Response to Submissions

Prepared for: **Grand Noble Project 1 Pty Ltd**

The State Significant Development Application (SSD-96272465) for residential development with in-fill affordable housing at 11–23 Rangers Avenue, Mosman was publicly exhibited between 4 December 2025 and 17 December 2025. During the exhibition period, a total of 185 submissions were received.

02. Shadow Proposed 11am June 21

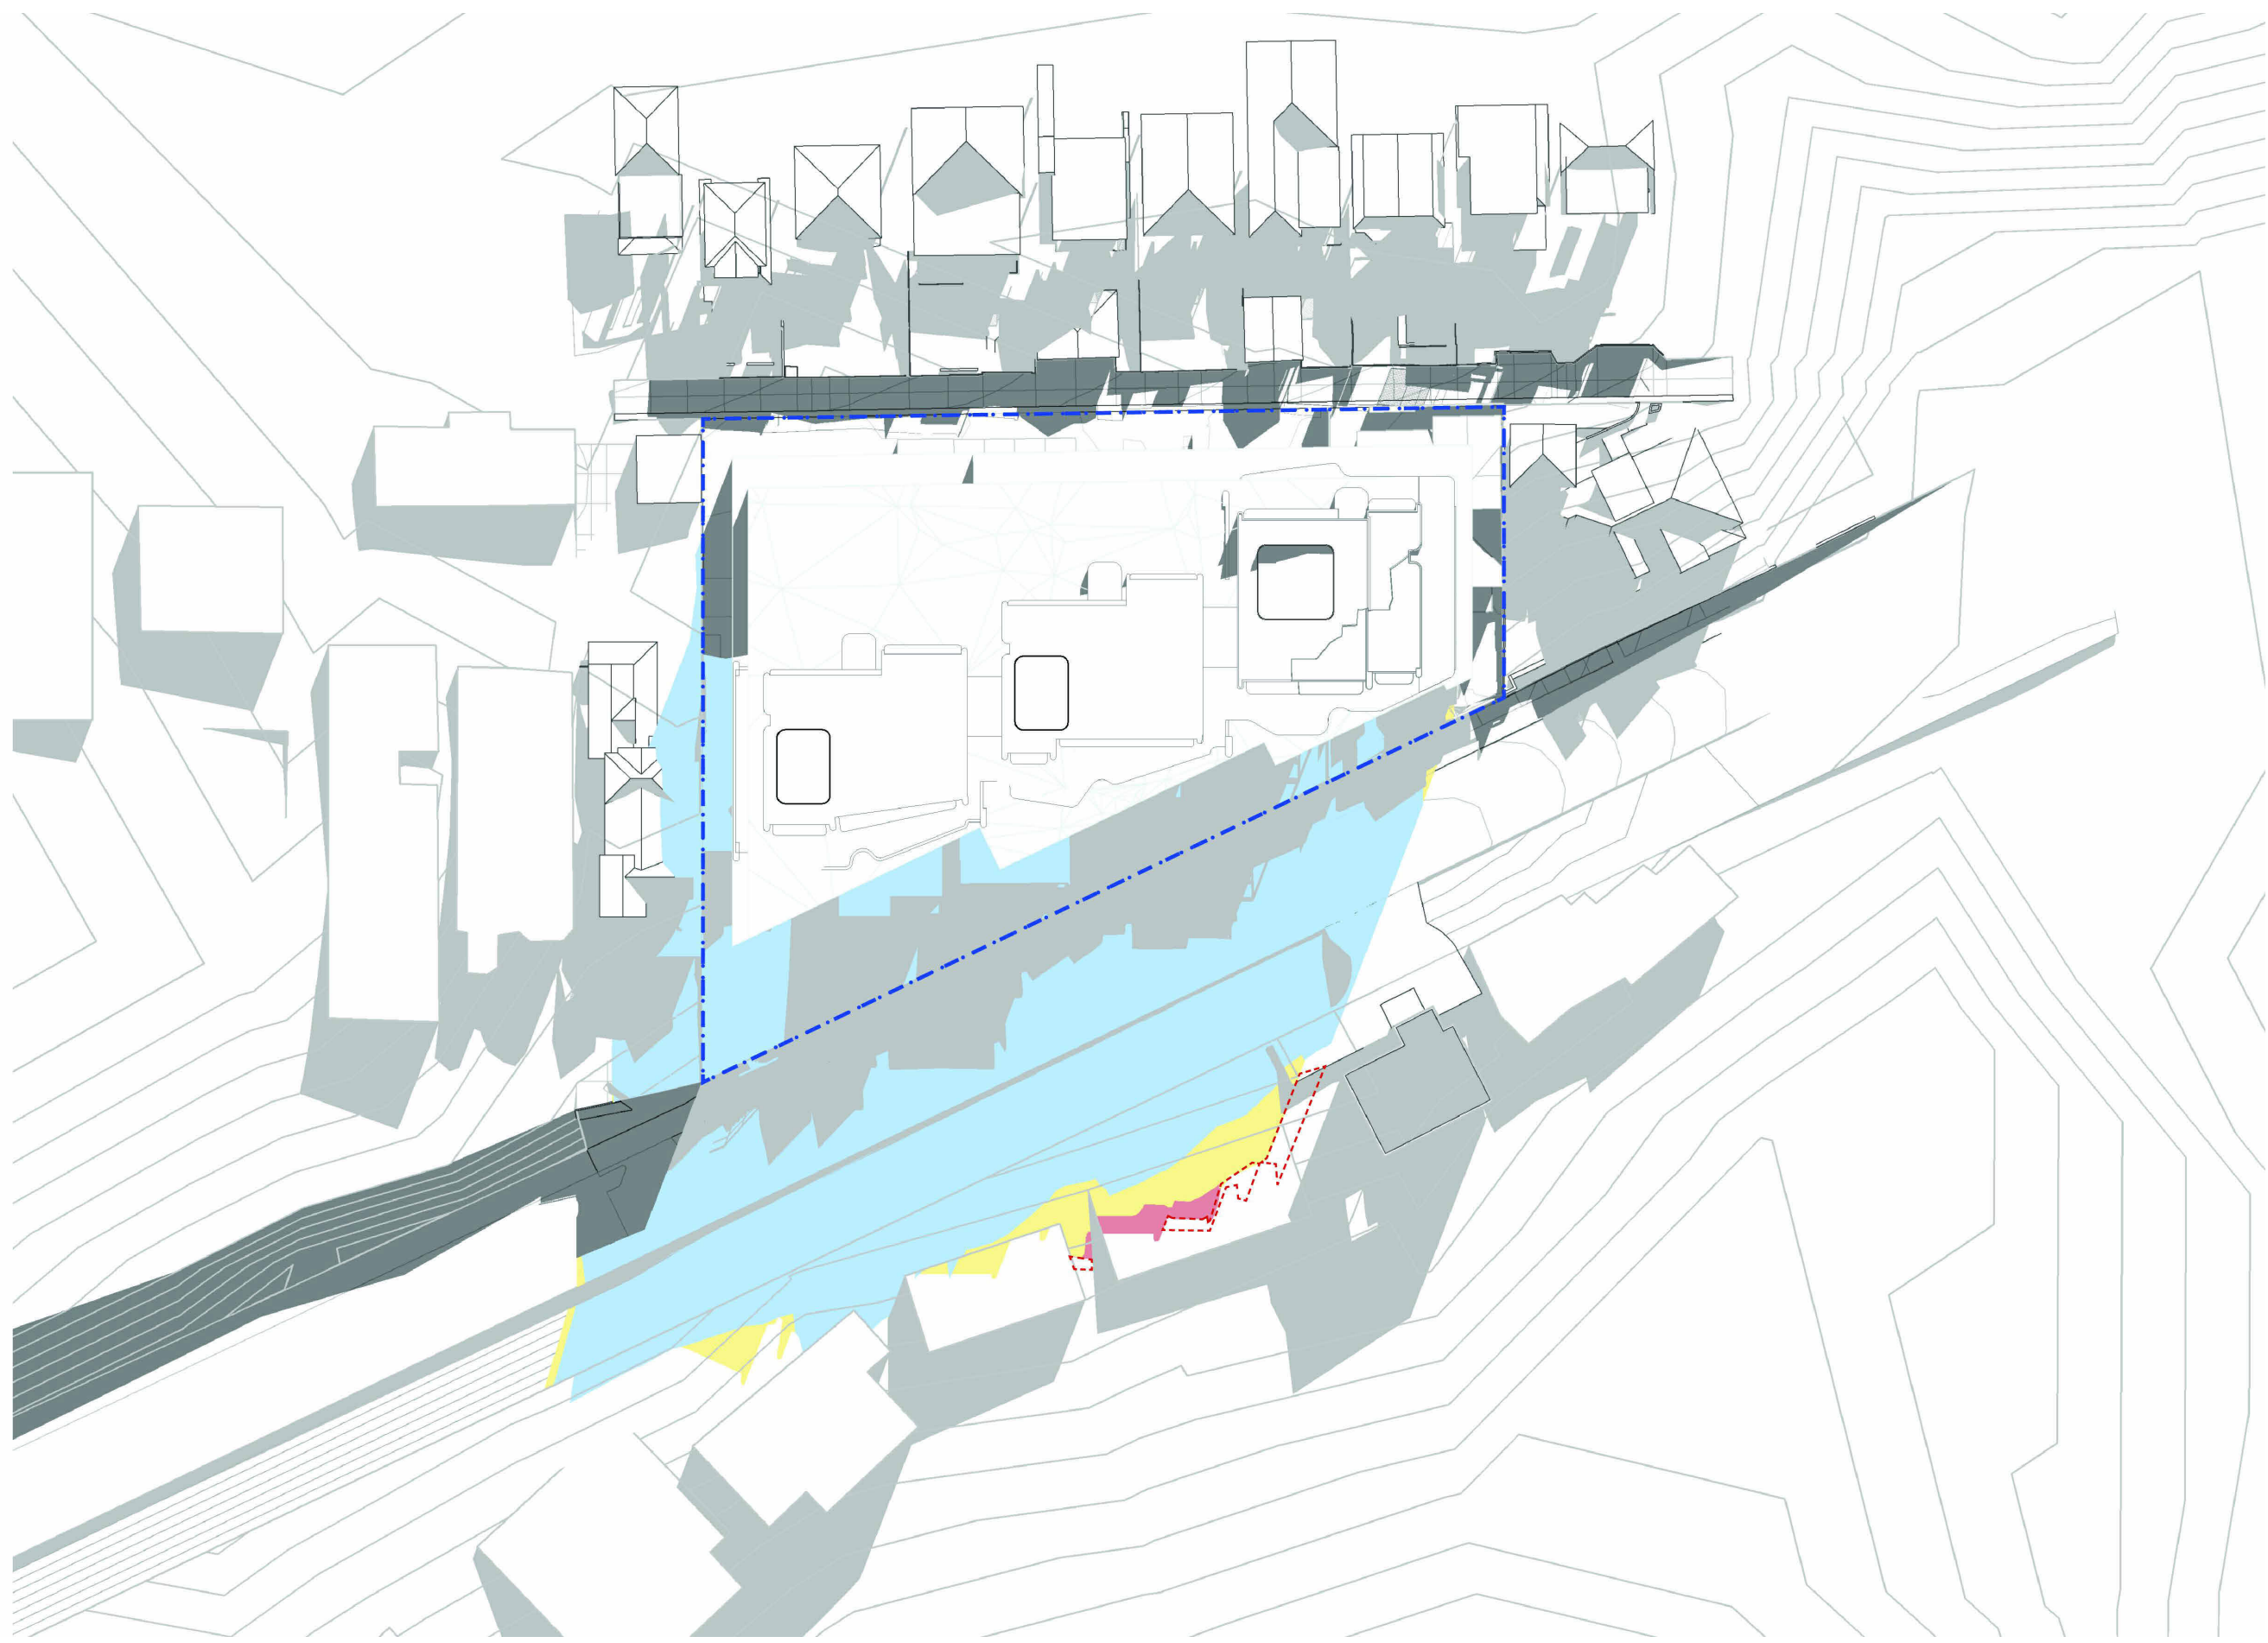
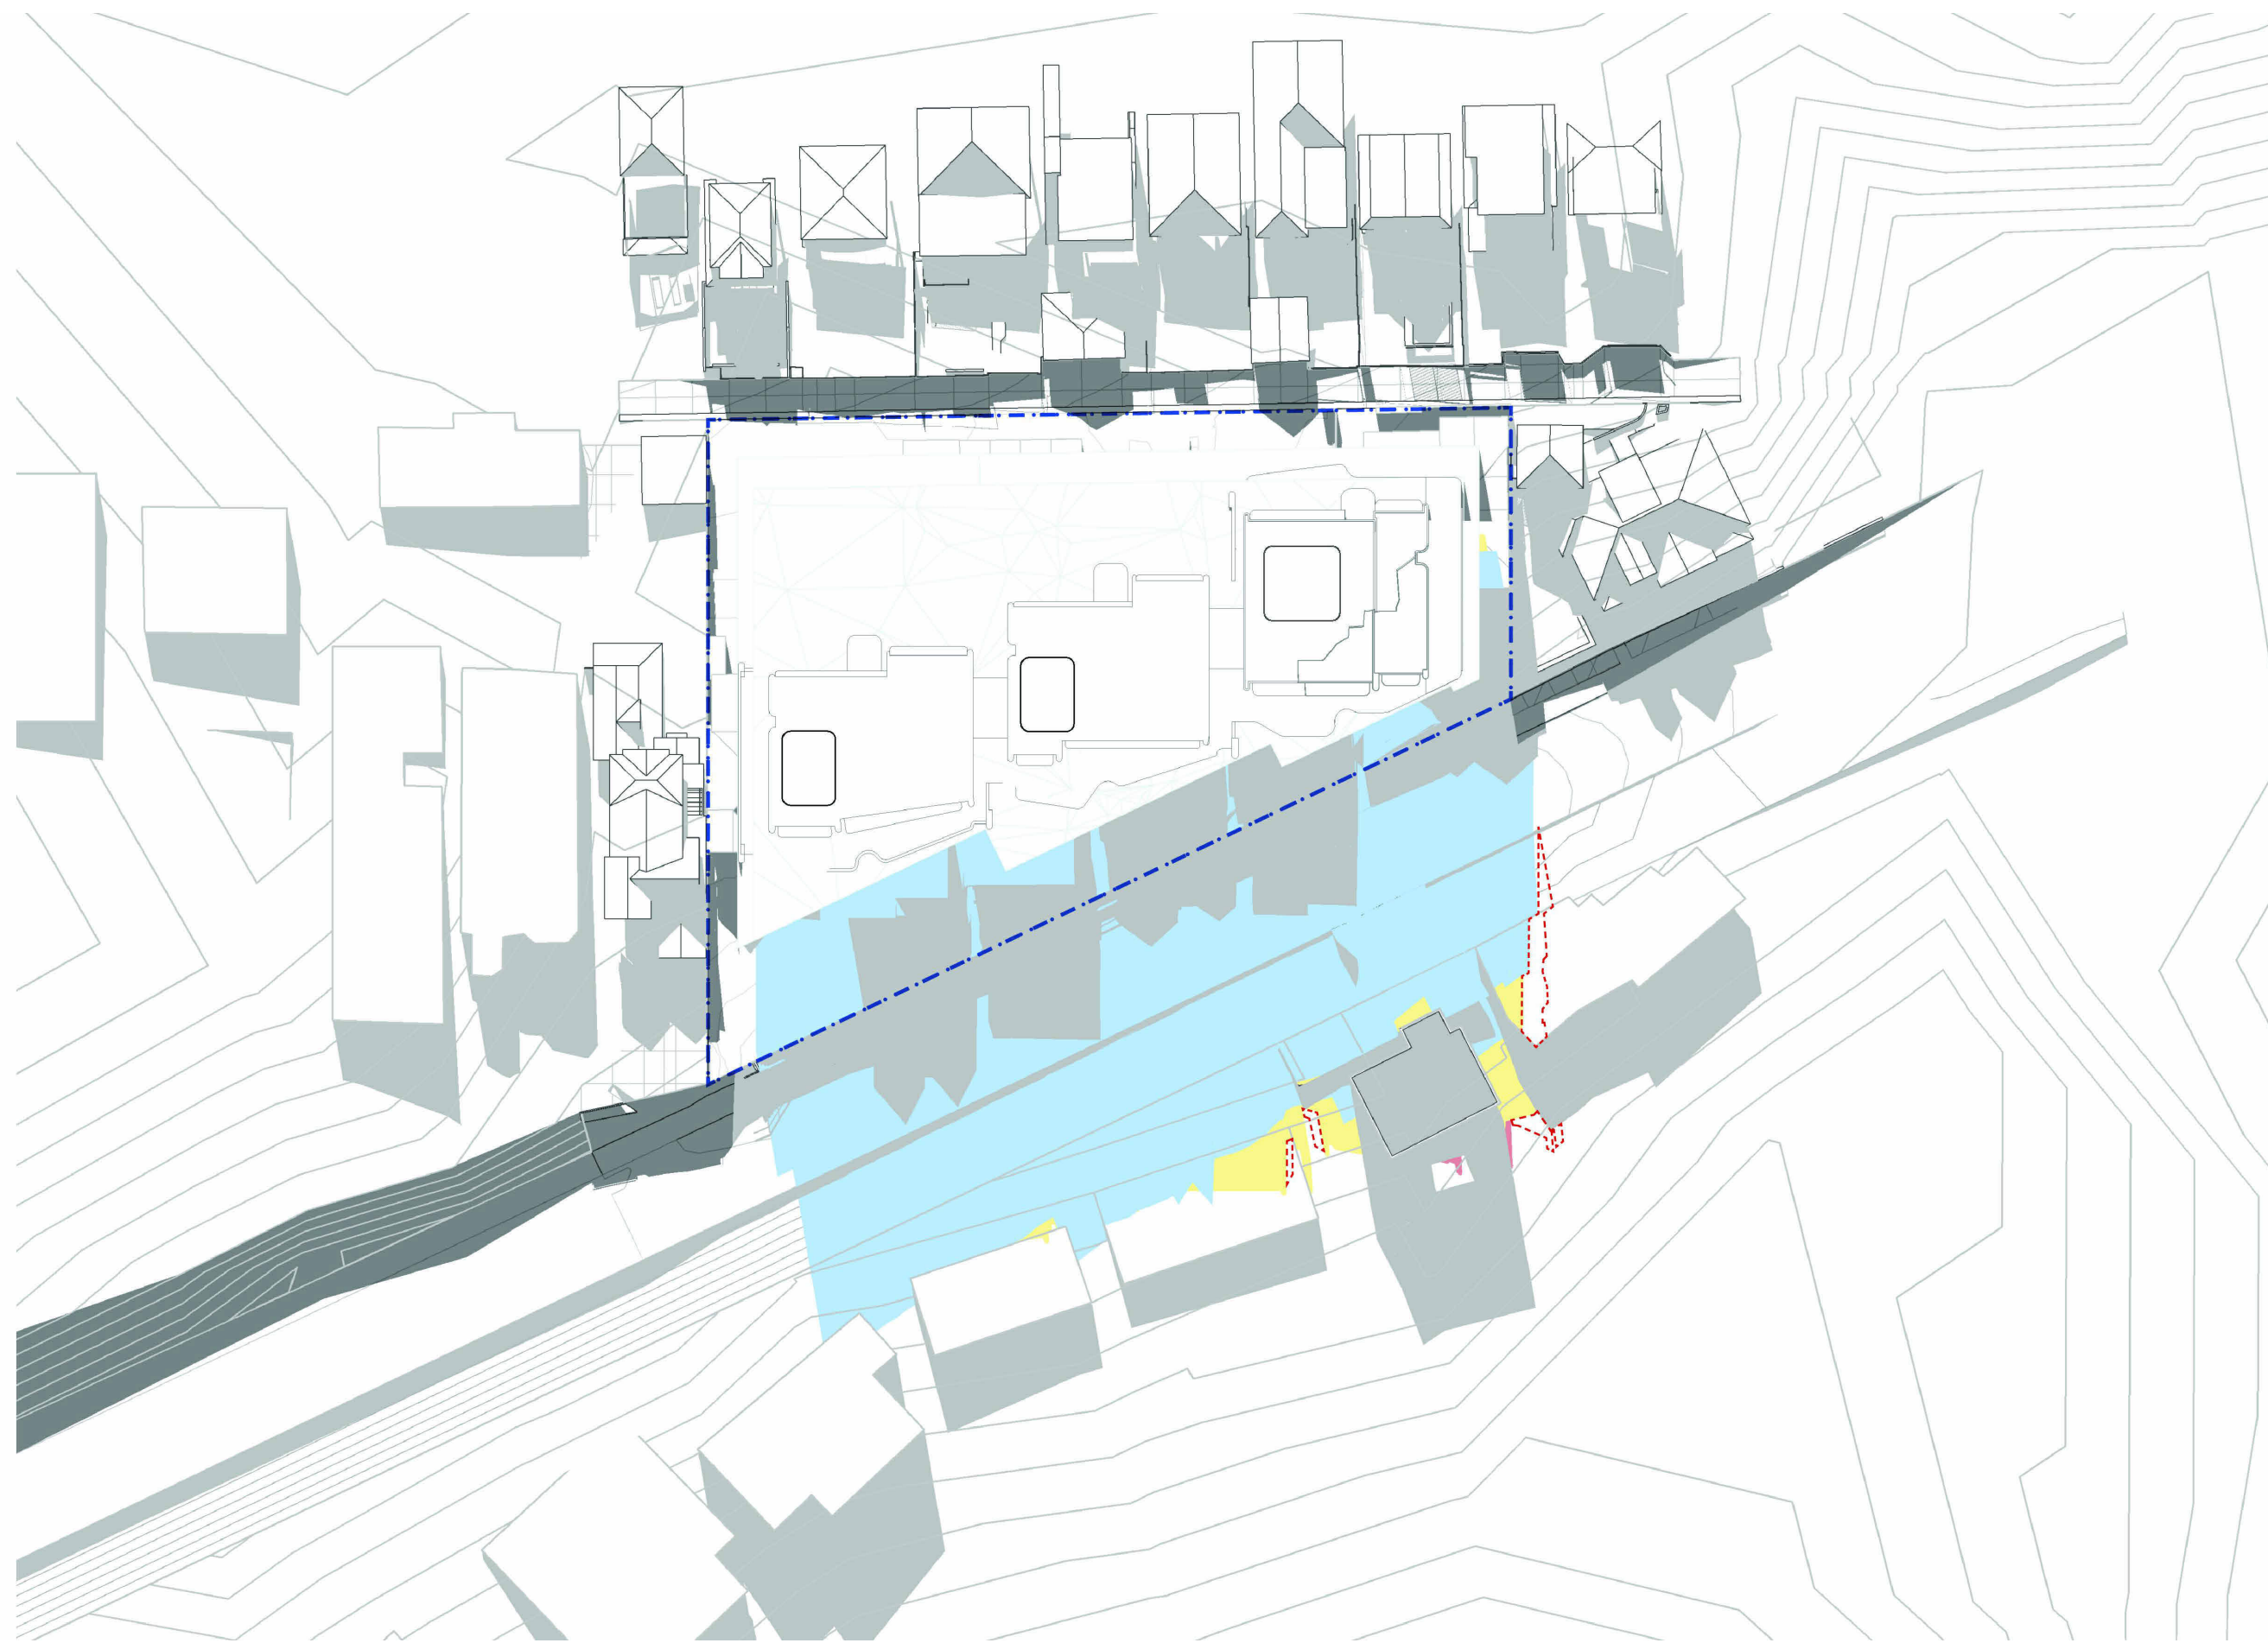
- Raises concerns regarding view sharing and amenity impacts, stating the proposal prioritises views from within the development, fails to demonstrate minimisation of view loss to surrounding properties, provides inadequate separation and transitions, and may worsen already constrained solar access south of Rangers Avenue.
